Corrections Narrative

DuBois Addition – 2955 74th Ave SE

3.7.23

WATER LINE PLAN
 SCALE: 1" = 20'
 2955 74th AVE SE
 NORTH MERCER ISLAND, WA 98040

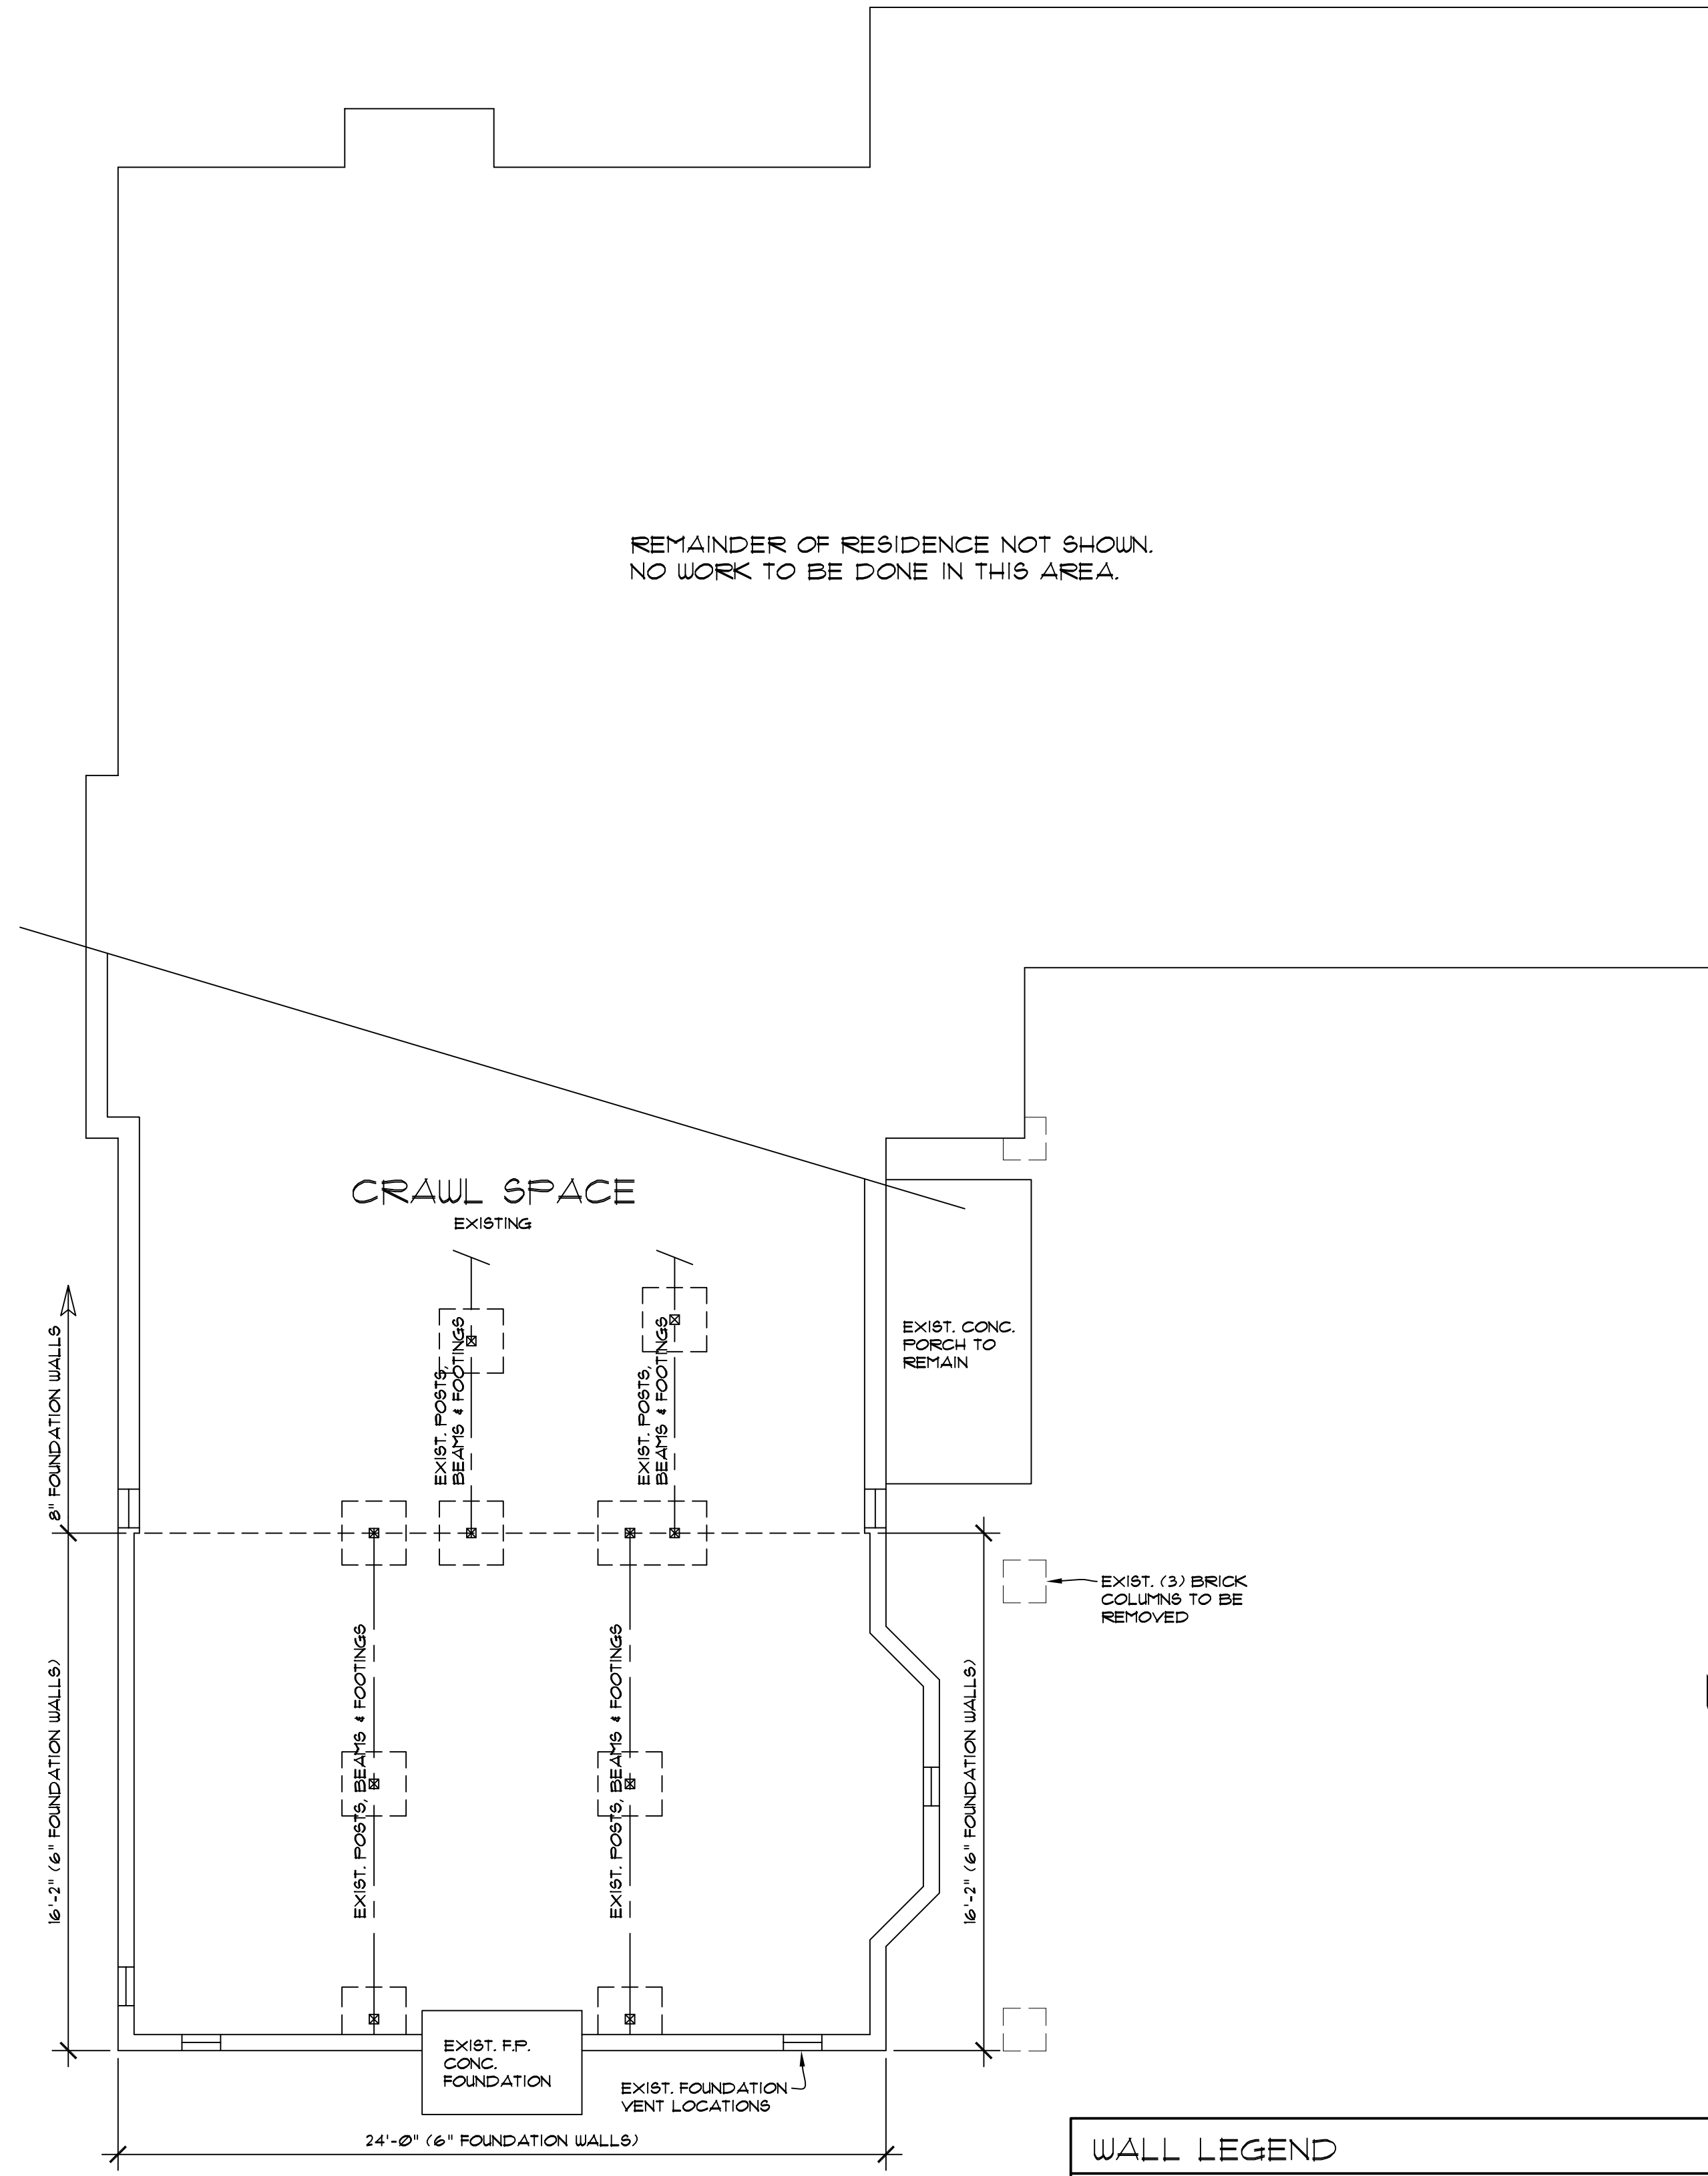
EASEMENT / WATER SUPPLY LINE

The survey of record has been updated to include easement information for the water supply line path to 72nd. Additional information regarding this easement has also been submitted, along with confirmation from Terrane (surveyor) that the subject site benefits from this easement. We have also added a new Water Line Plan (sheet A0.5) to supplement our site plan.
